A/121/15/PL

PLAN-010996

23/09/2015

Proposal: Demolition of existing stables & storage buildings & erection of 2 No. two bedroom holiday cottages & barn & associated sand school.
Site: Herons Farm, Dappers Lane, Angmering, BN16 4EN.
A/121/15/PL

Drg No. 459/03	Rev.
-------------------	------

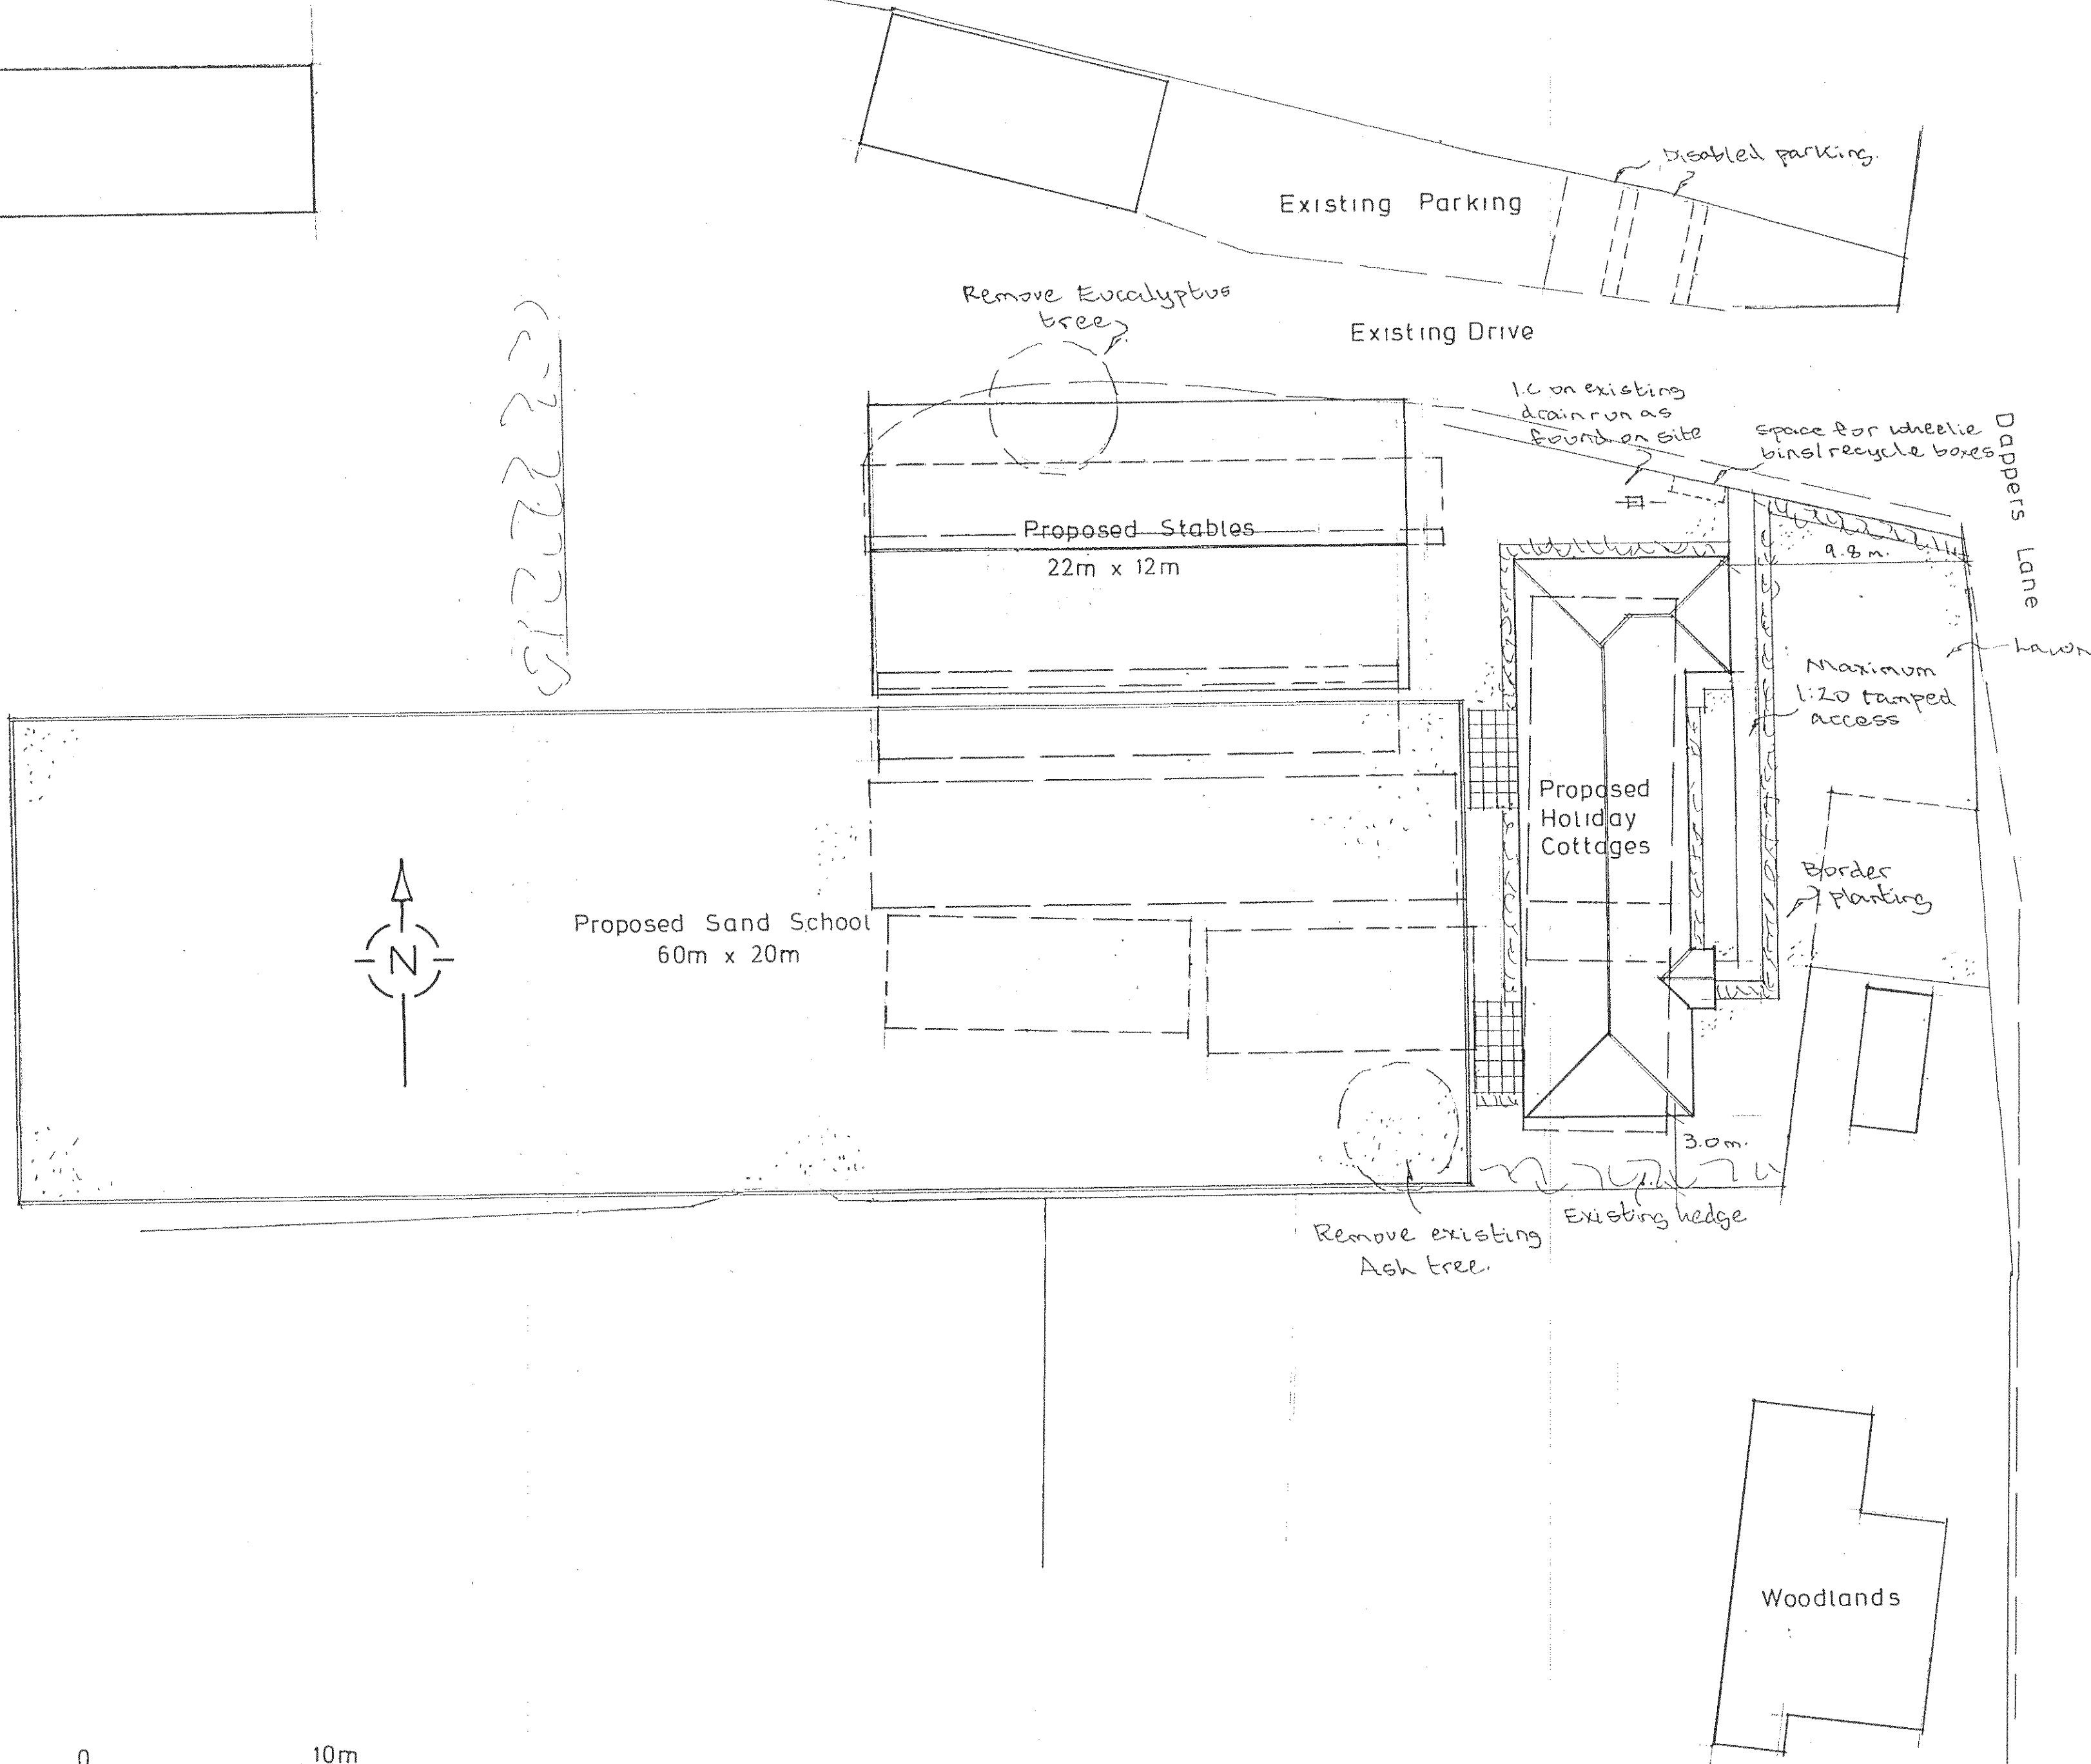
The submitted drawings shows an existing sewer with in the site not shown on our records. due to changes in legislation that came in to force on 1st October 2011 regarding the future ownership of sewers it is possible that a sewer now deemed to be public could be crossing the above property. Therefore, should any sewer be found during construction works, an investigation of the sewer will be required to ascertain its condition, the number of properties served, and potential means of access before any further works commence on site. The applicant is advised to discuss the matter further with Southern Water, Sparrowgrove House, Sparrowgrove,
